Environmental Health Division
1675 W. Garden of the Gods Road
Suite 2044
Colorado Springs, CO 80907
(719) 578-3199 *phone*
(719) 578-3188 *fax*
www.elpasocountyhealth.org

9910 Tomahawk Trail, Kennel, AL-22-19

Please accept the following comments from El Paso County Public Health regarding the project referenced above:

Mike McCarthy
El Paso County Public Health
mikemccarthy@elpasoco.com
719-332-5771
31March2023

SITE MAP
Lot #9, Block #1,
Indian Wells Subdivision,
9910 Tomahawk Trail,
Sch. No. 5227002009
El Paso County,
Colorado
Job #15-0363

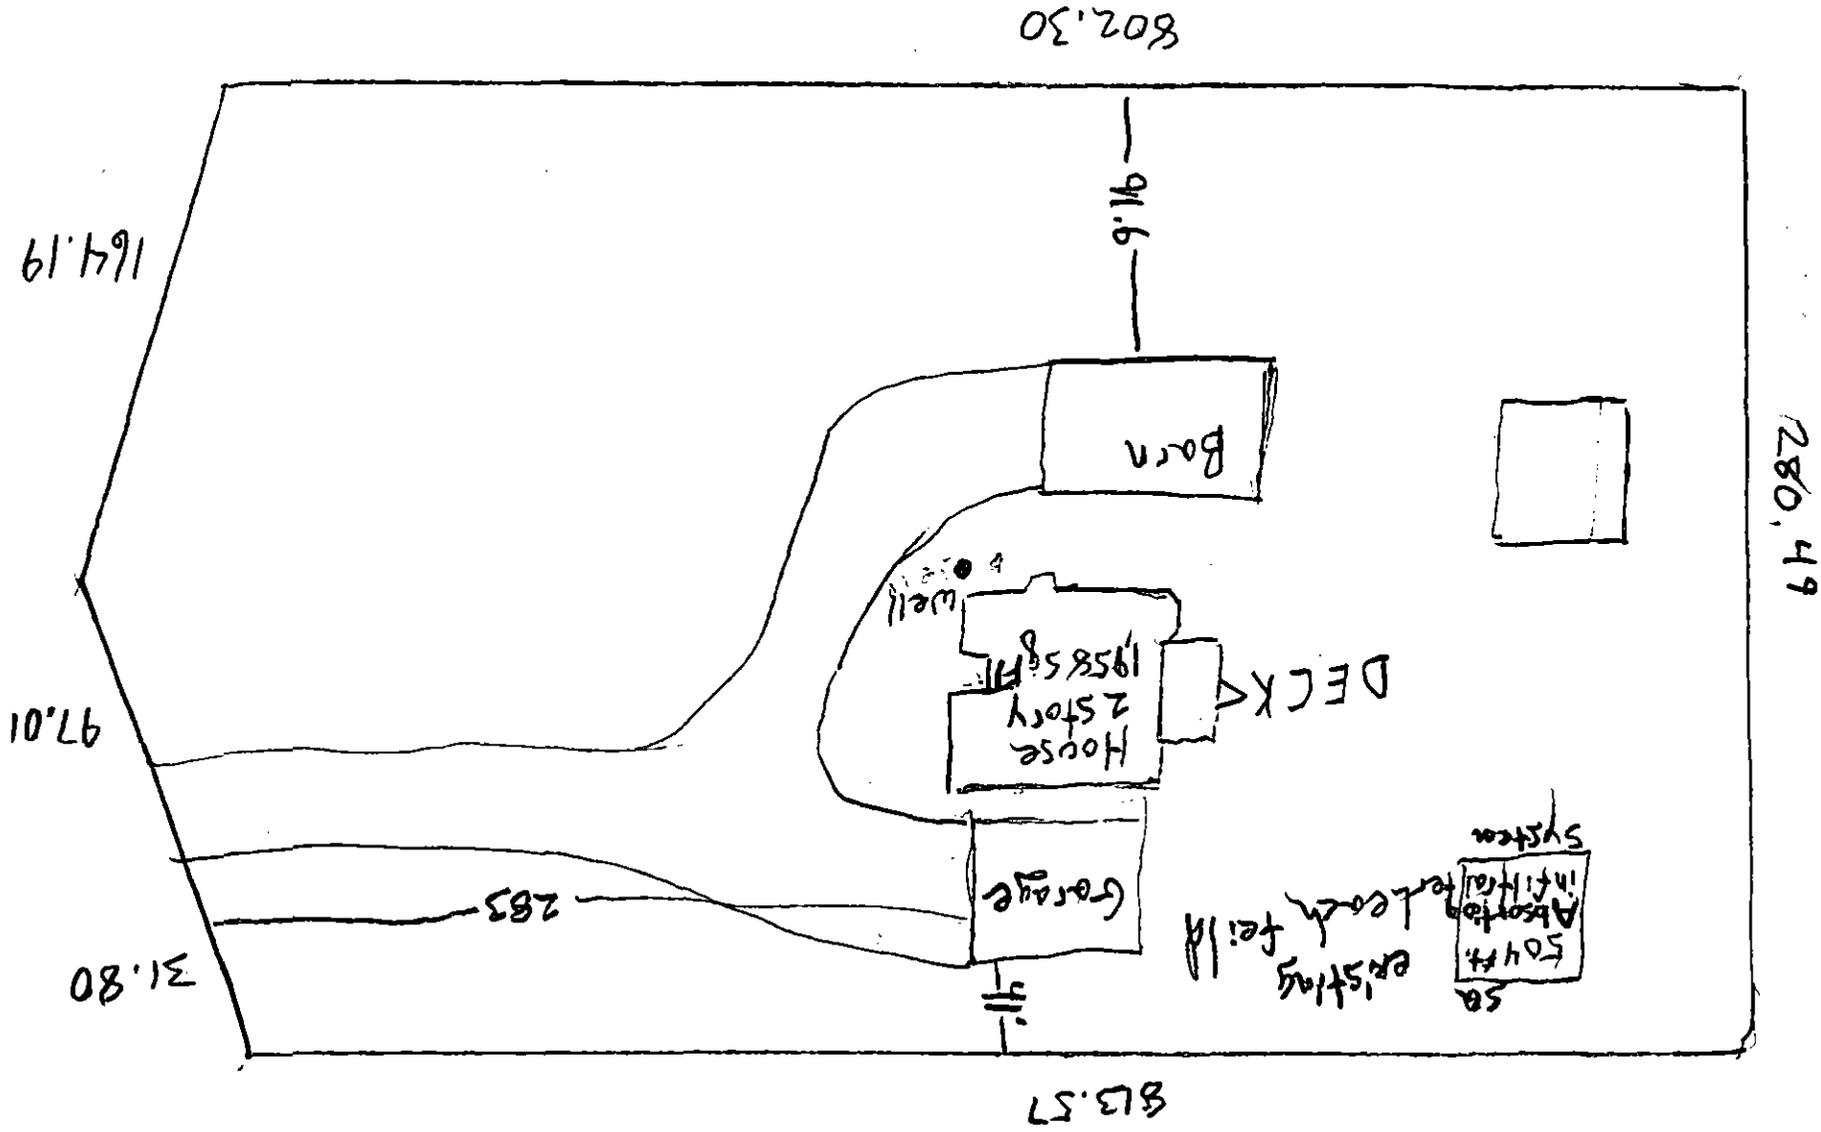
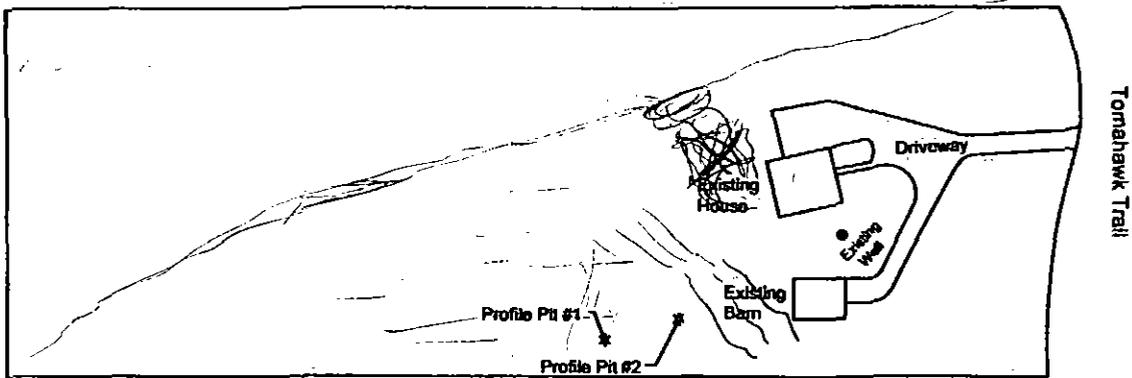
- Records of 2 permitted soil treatment areas were on file for the 4-bedroom house on the property. The permits are for the original system installed in 1994, and an additional soil treatment area installed in 2015. The OWTS component locations on file at El Paso County Public Health and accessible through the El Paso County Assessor's Office website property search page. Please make sure that components of the OWTS are protected from vehicular traffic and other means of compaction.
- Please reserve a secondary site on the property for the possibility of a repair, addition, or replacement of the existing soil treatment areas.
- El Paso County Public Health recommends storing animal food in impervious containers with lids in an effort to minimize rodents and insects.
- Animal waste should be managed properly to help control odors and minimize flies and other insects.
